STERLING RANCH EAST FILING NO. 2

CONSTRUCTION PLANS

SPRING 2023

TITLE SHEET

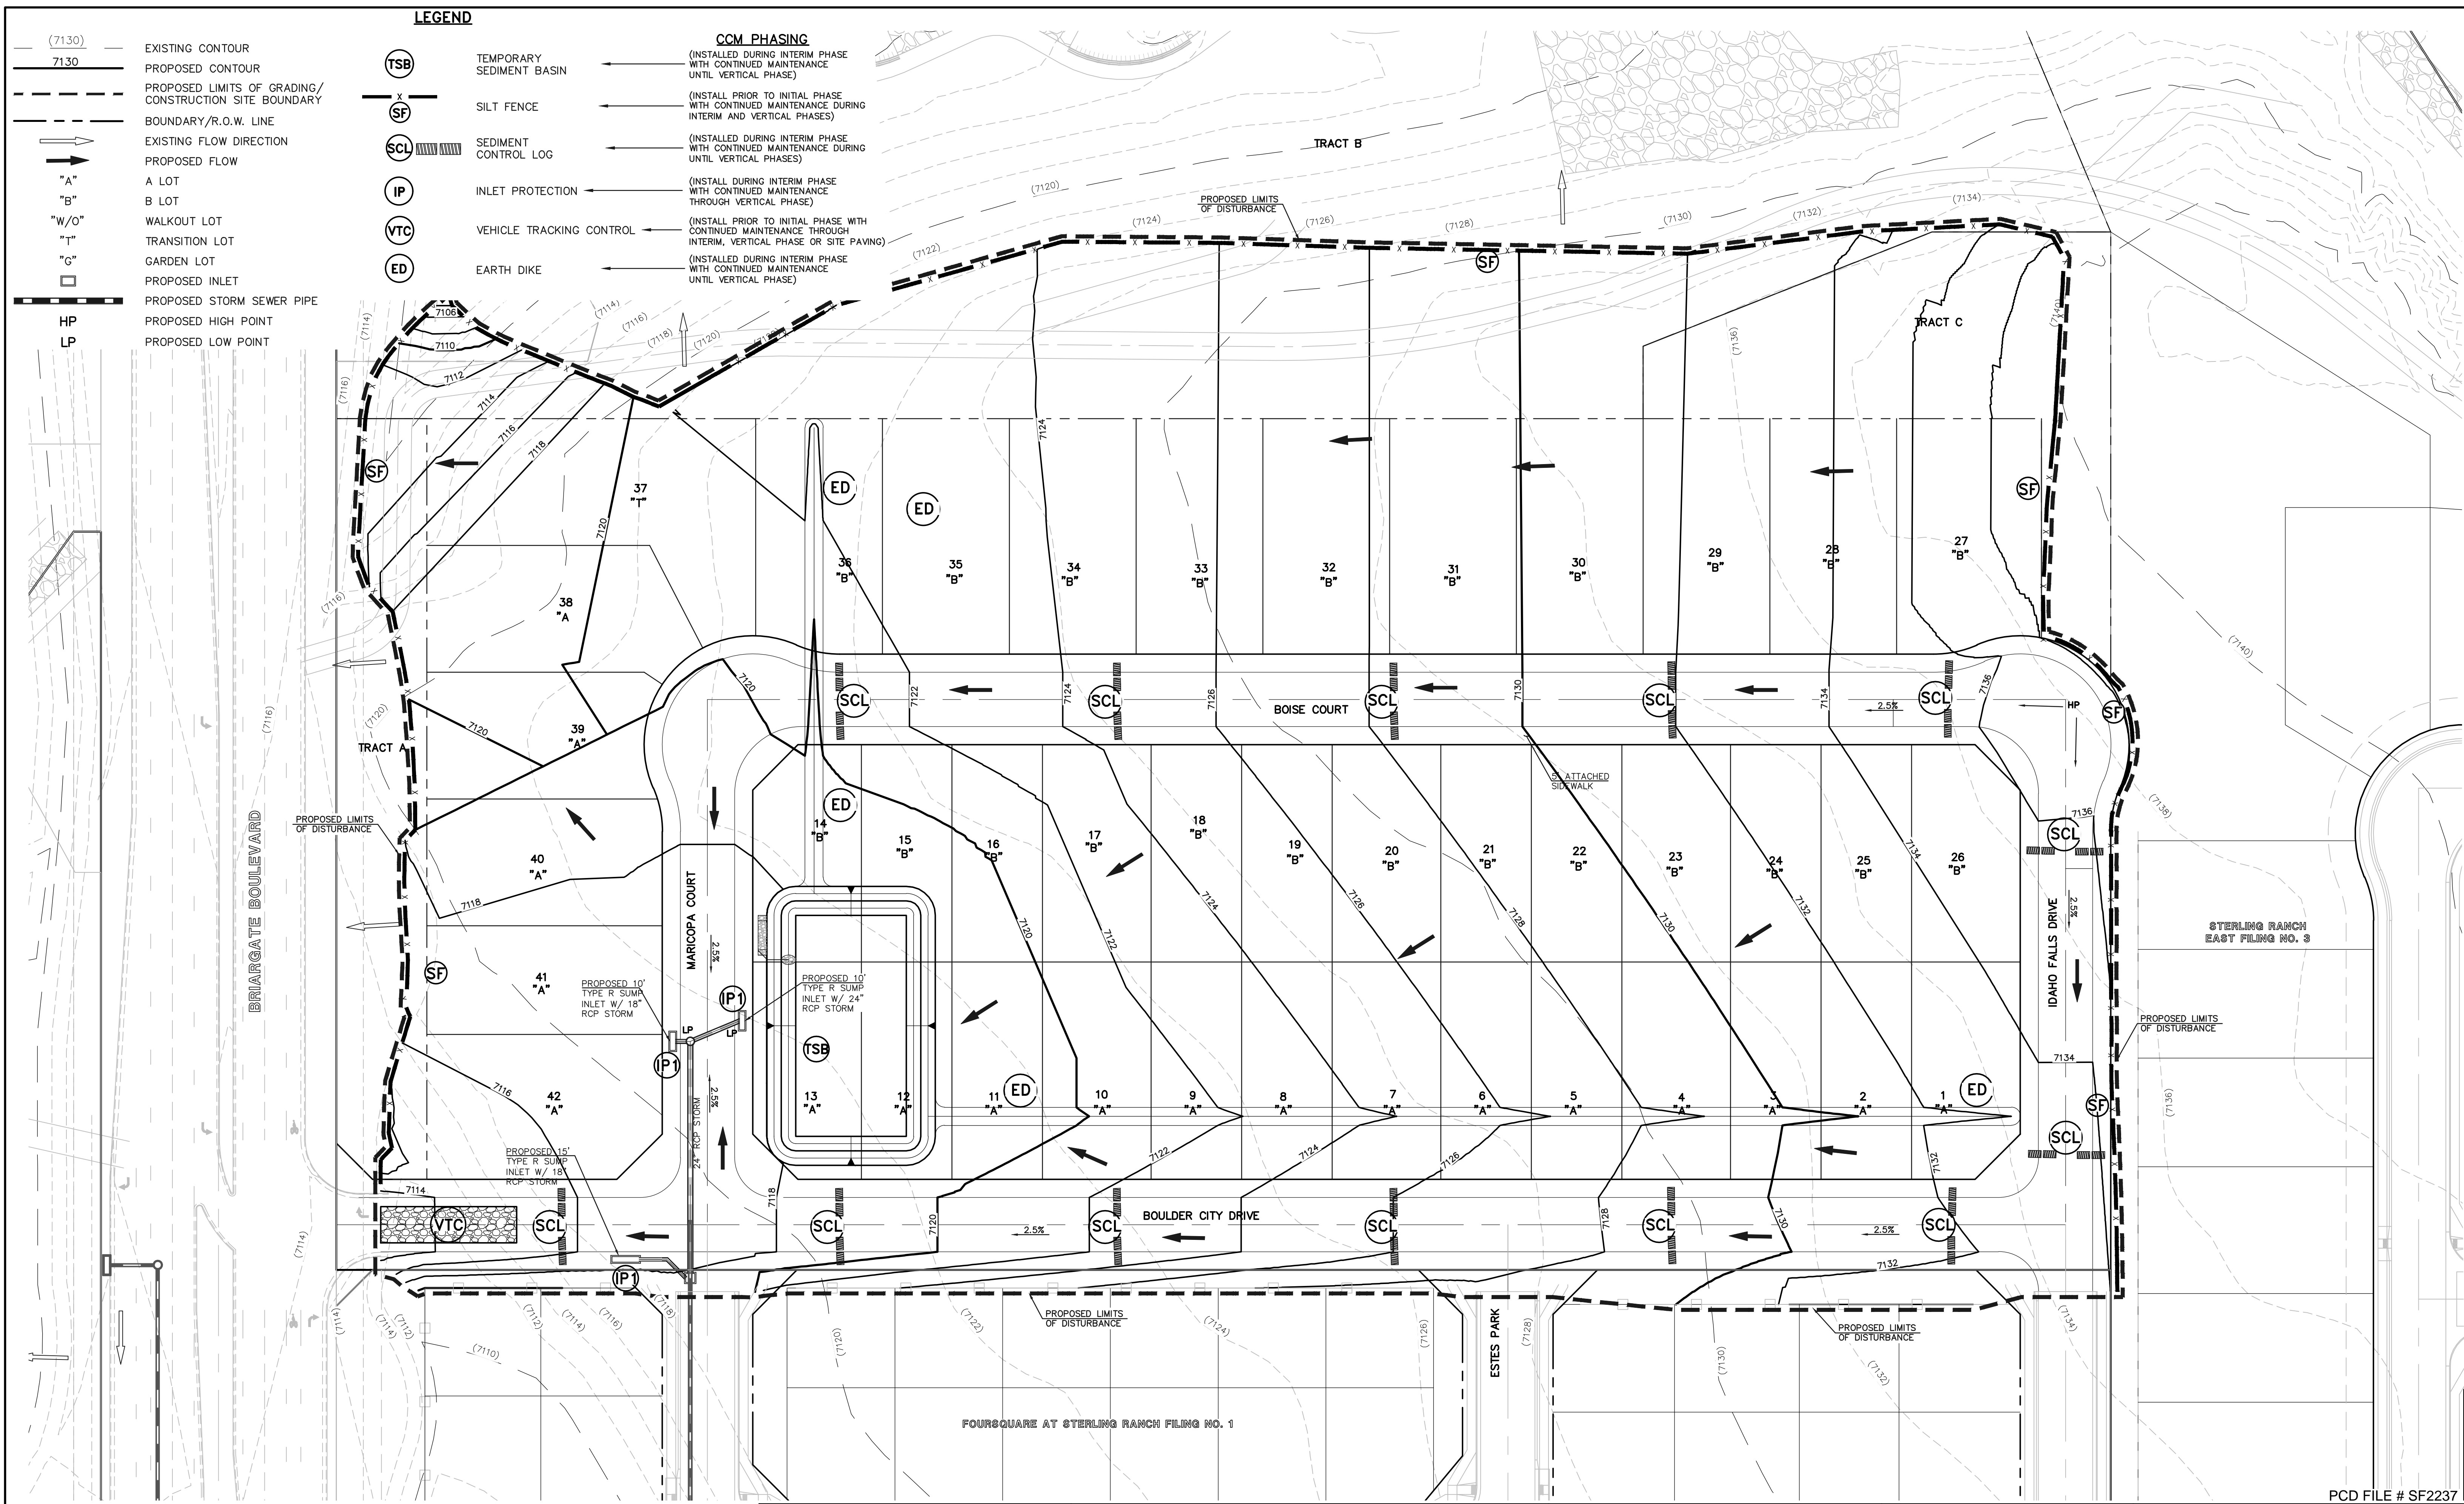
Add seeding, mulching, and straw bales to Legend and show them on the plans since they are included in the FAE Form

Show location on plans. With ~11 of the total 16 acres disturbed during overlot grading, a TSB is required. Also flows from the site will need to be conveyed to the TSB(s) somehow via rough cut streets and swales. Show this initial/interim condition. It might be easier on a separate sheet to show temp BMP conditions prior to utility and road installation.

show location on plans.

Show seeding, mulching, and/or ECB in this area
